**Consultation Response from Alan Smith,
KC Waste Strategy(Refuse & Recycling)**

2025/91122 Turnbridge Mills, Quay Street, Huddersfield, HD1 6QT

Date Responded: 23/06/2025

Responding Ref: WPS 25 - 015

Drawing: Proposed Site Plan

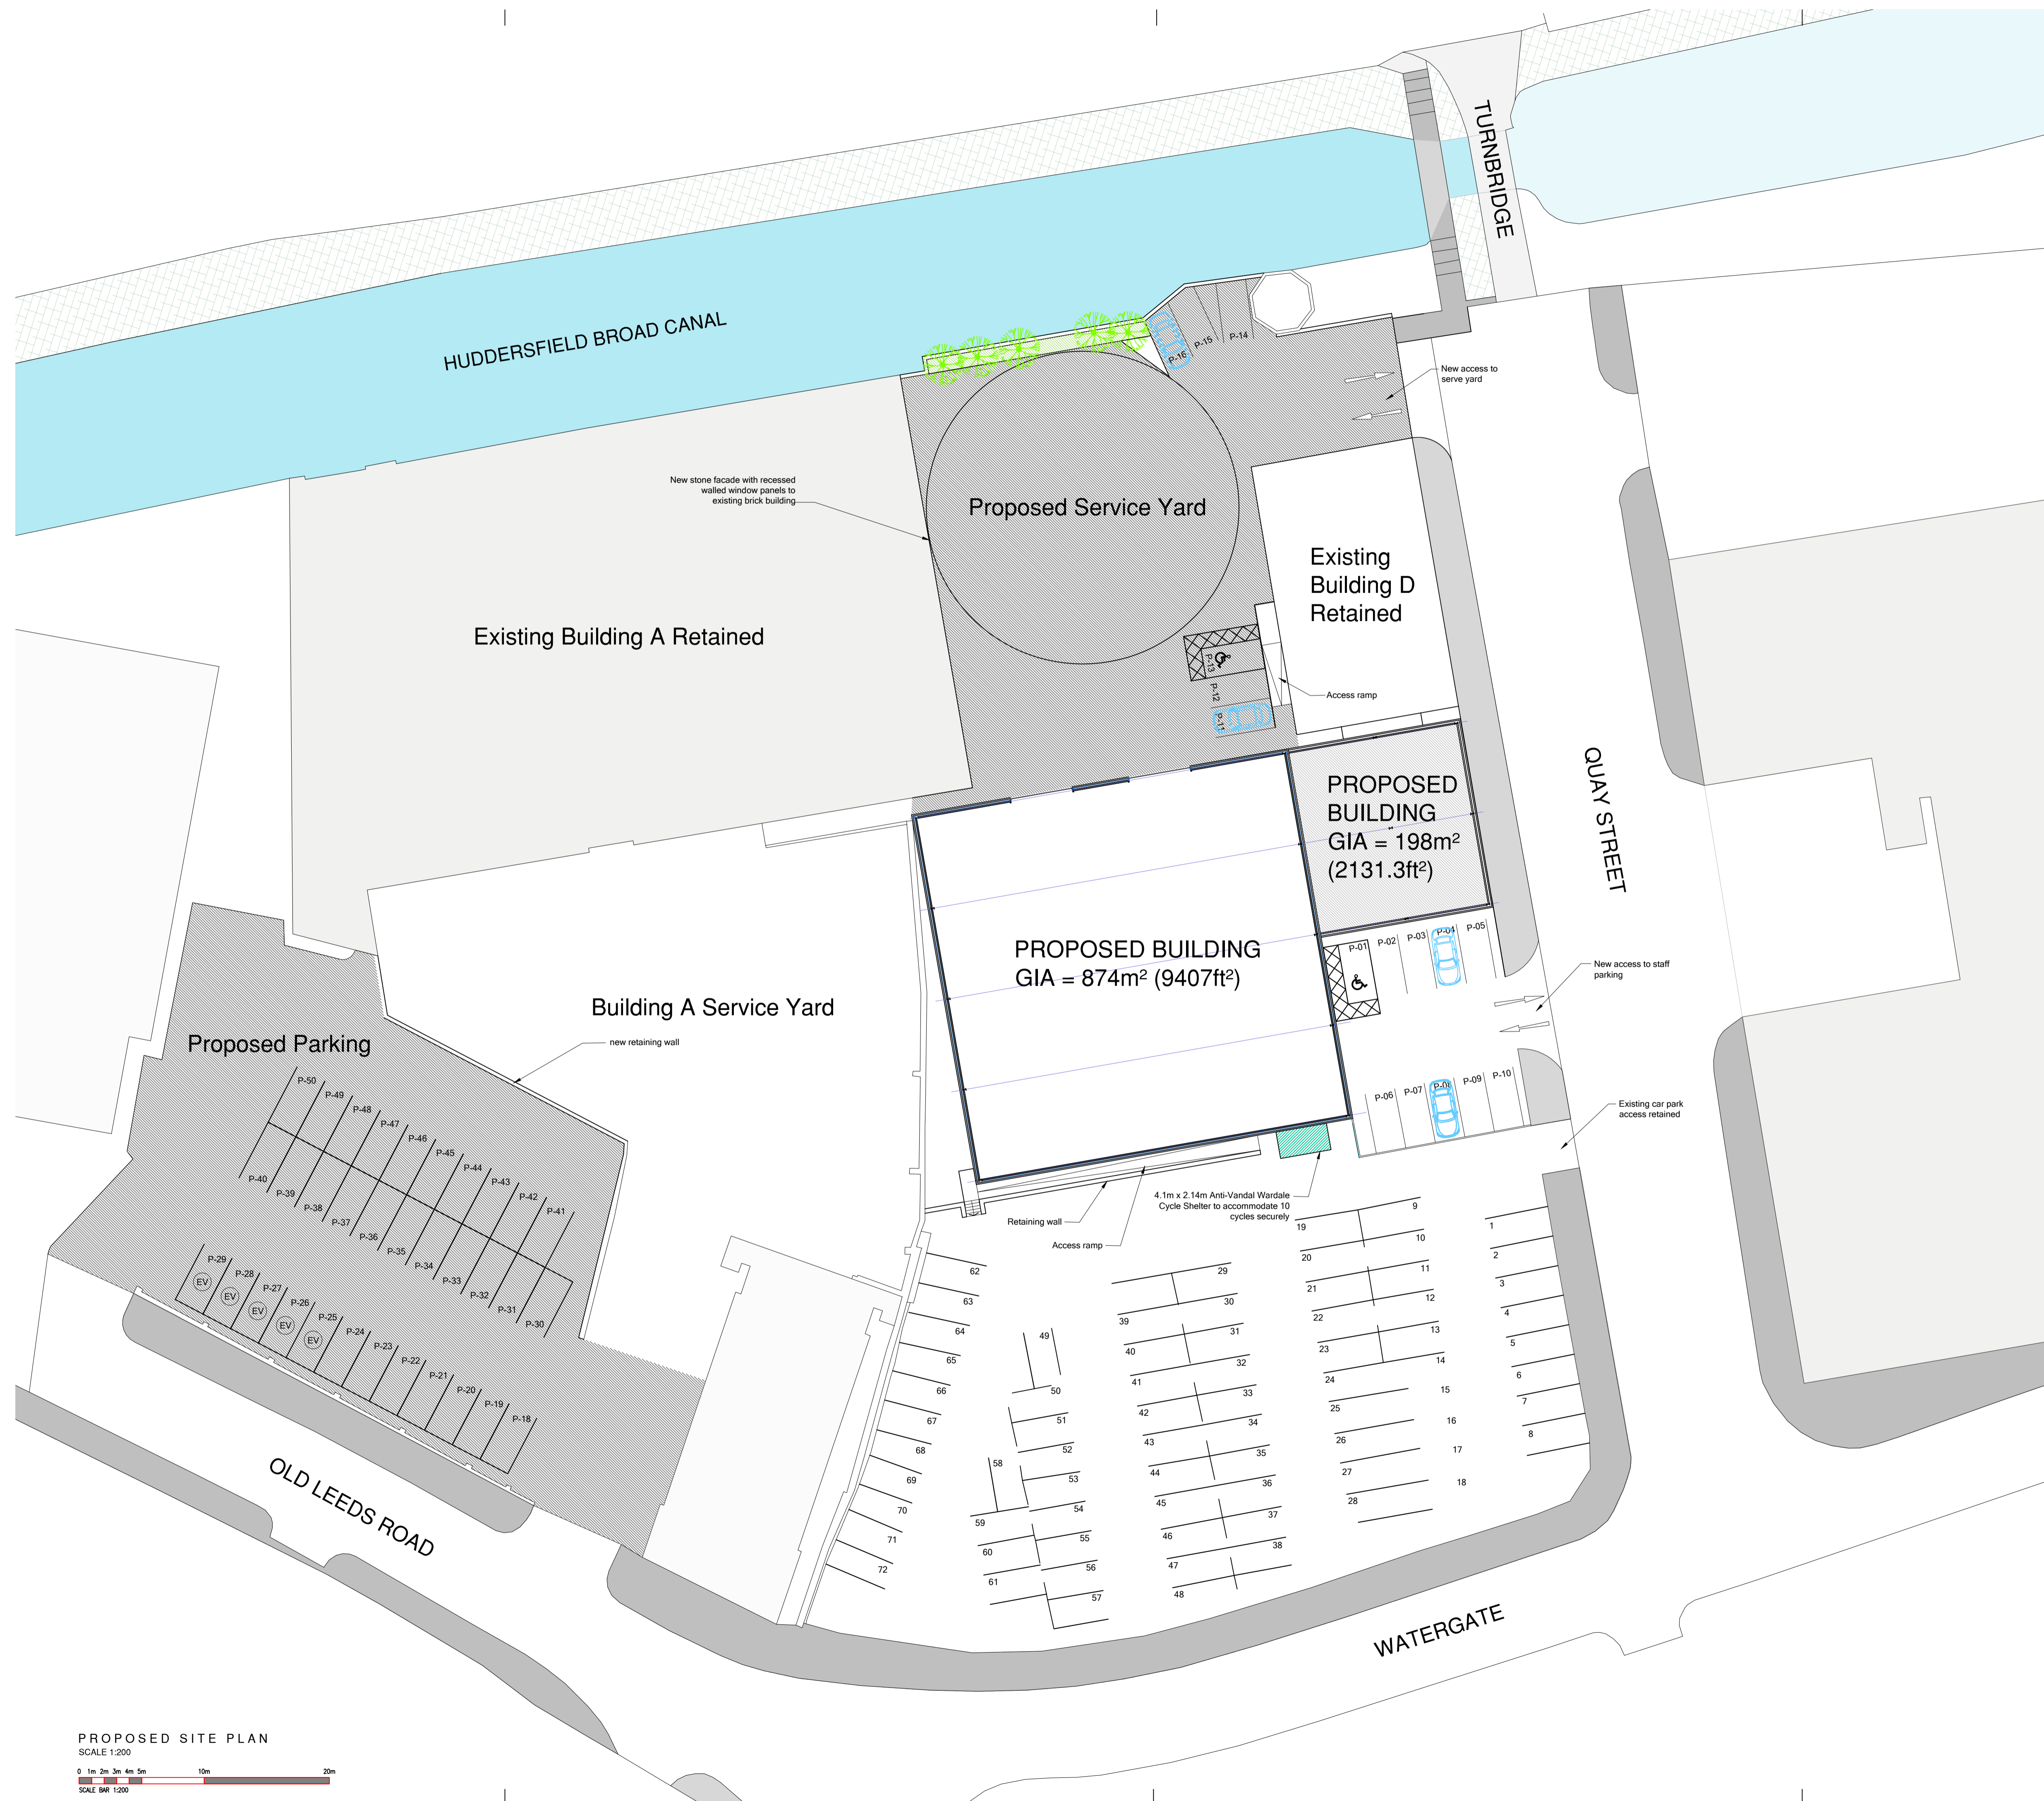
In the application it is noted that there is currently no arrangements for the handling and collection of waste. With a new commercial development, it is difficult to accurately estimate the potential waste generation unless the site operator has experience from comparable sites. If the operator is not intending to store waste within the buildings and utilising reverse logistics with delivery vehicles being used to transport packaging and food wastes to a central collection or distribution depot for onward treatment, recycling/disposal or direct delivery to treatment facilities then there needs to be a waste compound on site.

Additional information is required detailing waste storage, number and size of containers, capacity and design of the waste storage compound(s) including, surfacing, security and fire prevention measures.

Confirmation is sought that the road layout enables vehicular access to the Bin Collection Point(s) and details are required as to show how waste collection will be achieved via an RCV, FEL or skip wagon. There is no indication as to whether bins will be dragged from the rear of the retail units to bin collection points for loading. Reversing of RCV's presents an established health and safety risk. Any proposals should consider the potential impact on pedestrians and motorists when waste collection is occurring at the site.

- A) Before development commences, further details to ensure suitable storage, and access for collection of wastes from the commercial units, shall be submitted to and approved in writing by the Local Planning Authority. The approved details shall be provided before first occupation and shall be so retained thereafter.
- B) Before development commences, details of the management and maintenance of refuse storage areas by a designated private management company shall be submitted to and approved by the Local Planning Authority, including access for waste crews.
